# FINAL DRAINAGE PLAN AND REPORT

## HOT MIX HEIGHTS DEVELOPMENT

### AMENDED PLAT BARBARICK SUBDIVIISON

PCD File #  
PPR2332

DRAWN BY: O.E. WATTS
DATE: 6-29-17
DWG. NO.: 18-5223-02
SURVEYED BY: DEV, ESW THRU 7-18-19

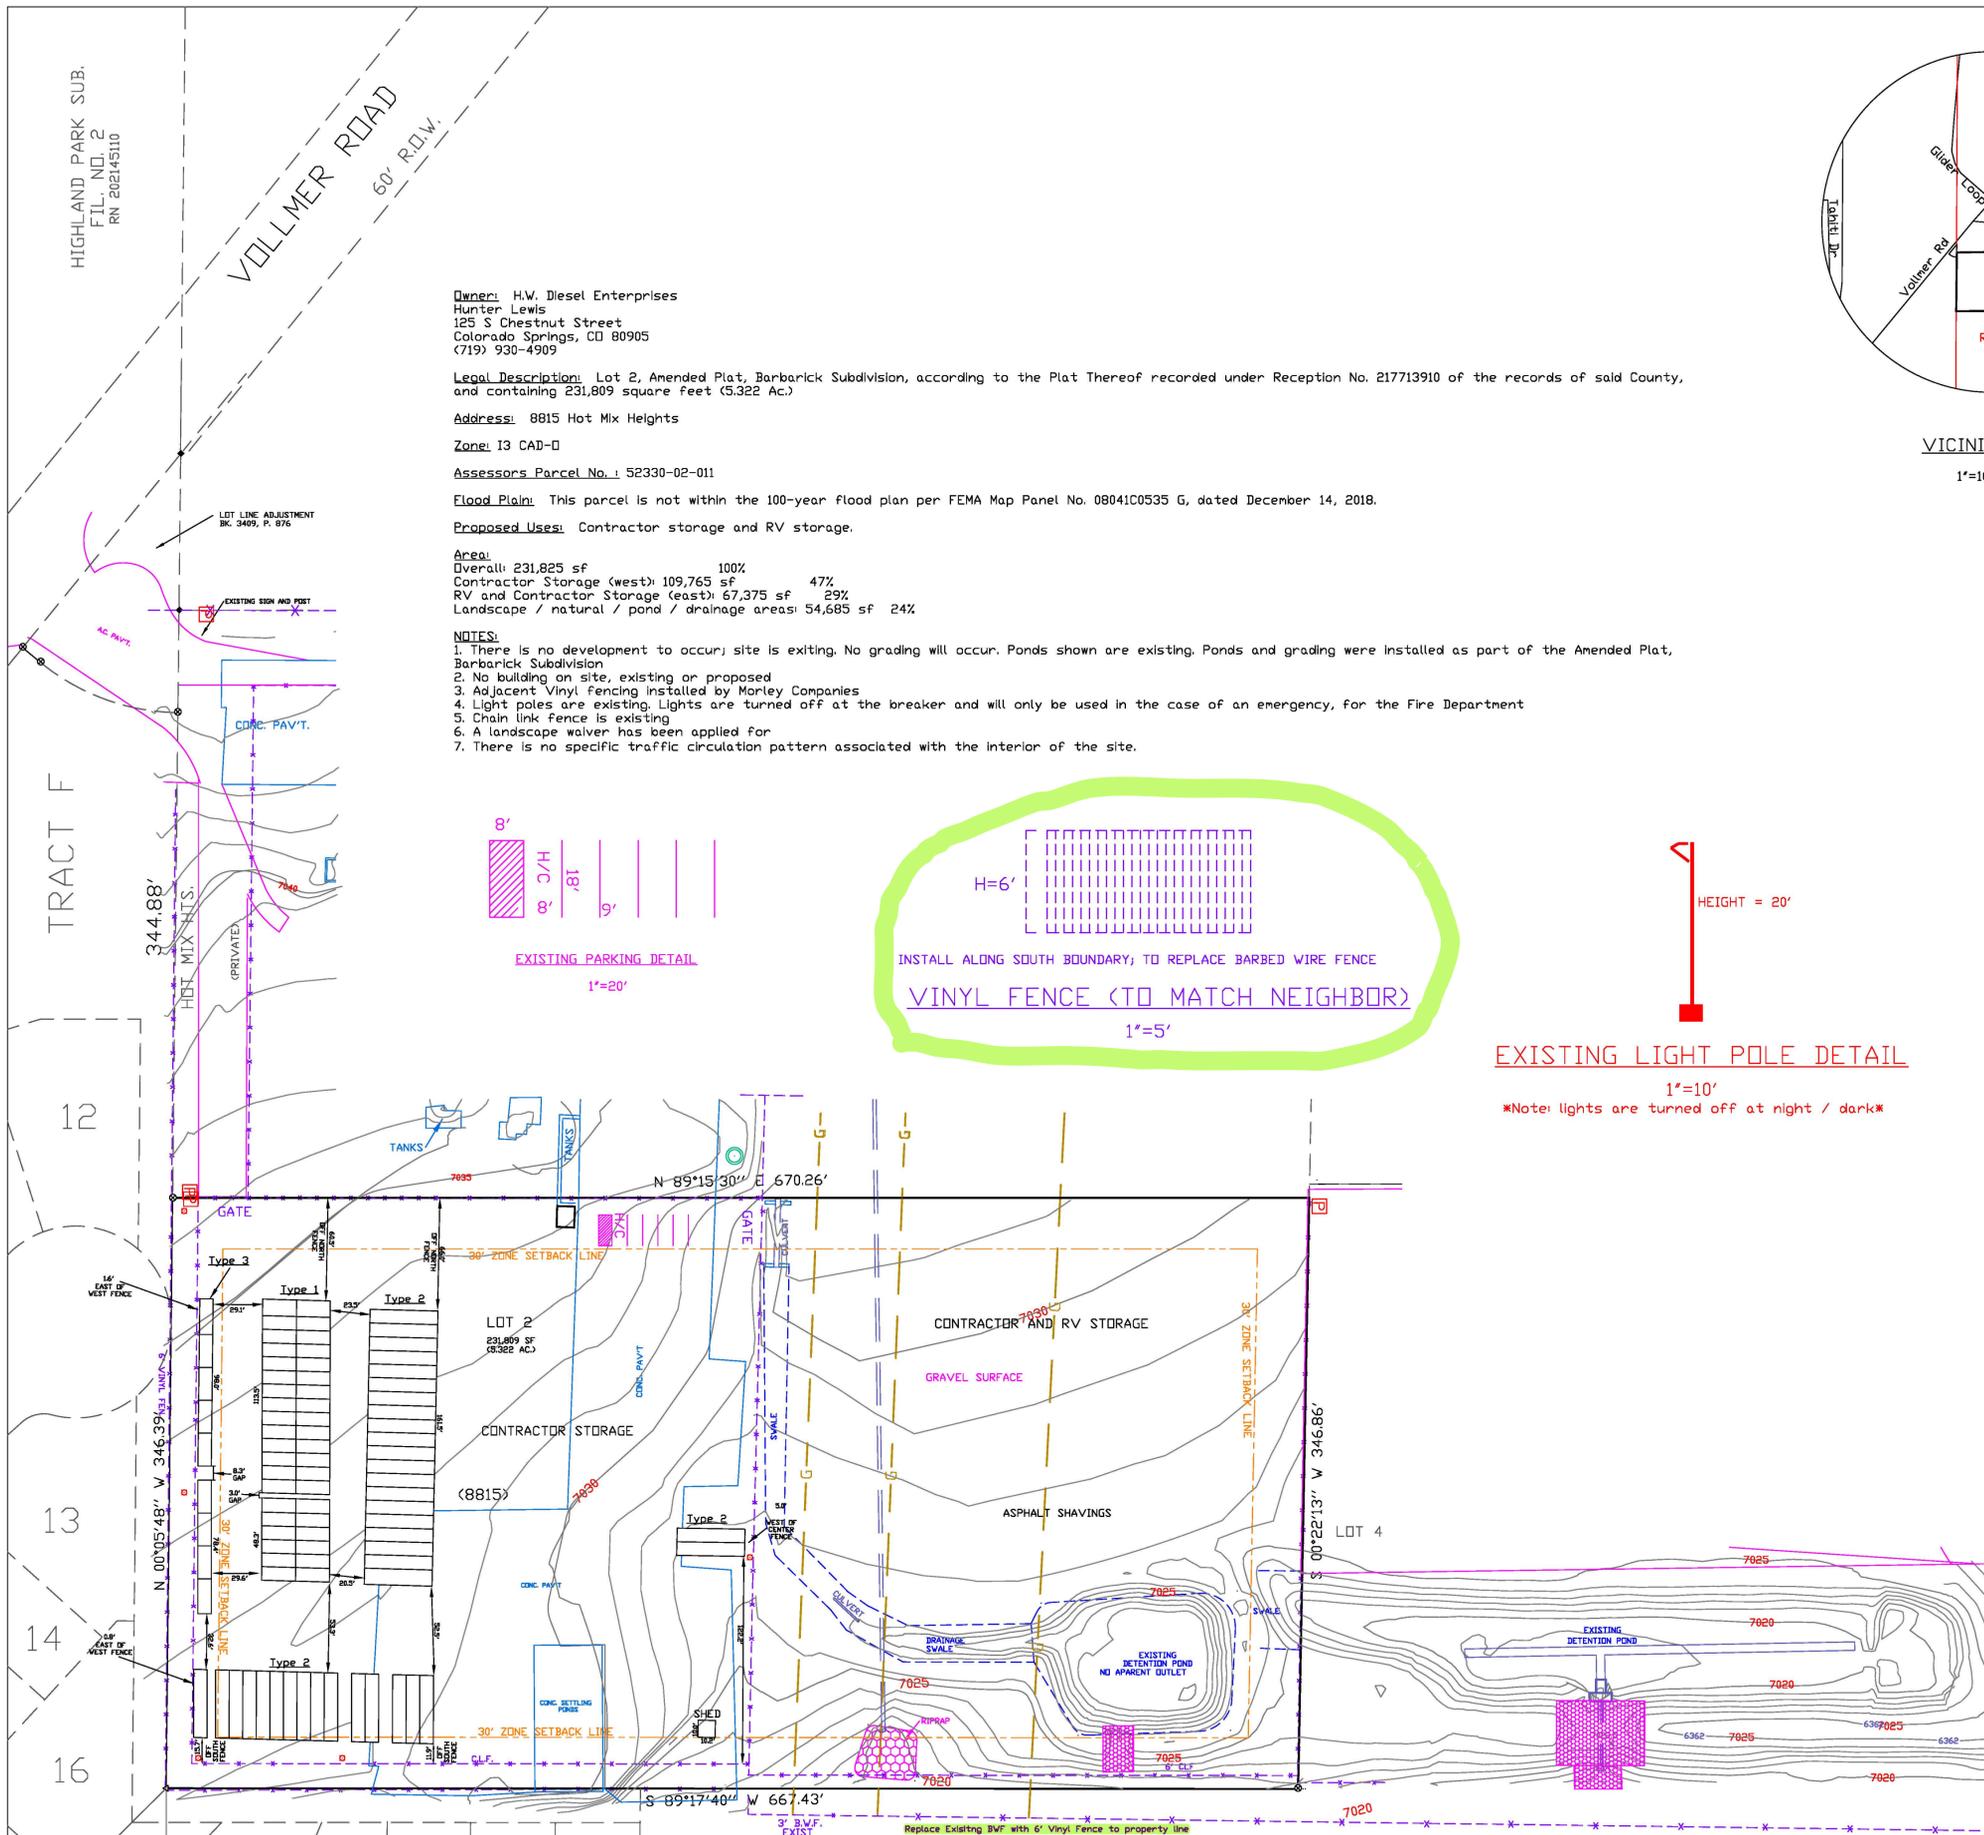
Show this proposed grading on the Site Development Plan drawing and Drainage Map below.

Show this proposed grading on the Site Development Plan drawing and Drainage Map below.

The original Matrix design (PDF pg 39 of 76 of that report) shows the make stage at 6.5ft. Where did this extra 3.5ft come from? On your SDP drawing, I'm still only seeing ~6ft via contours 7019 to 7025. Revise these inputs to match conditions of pond.
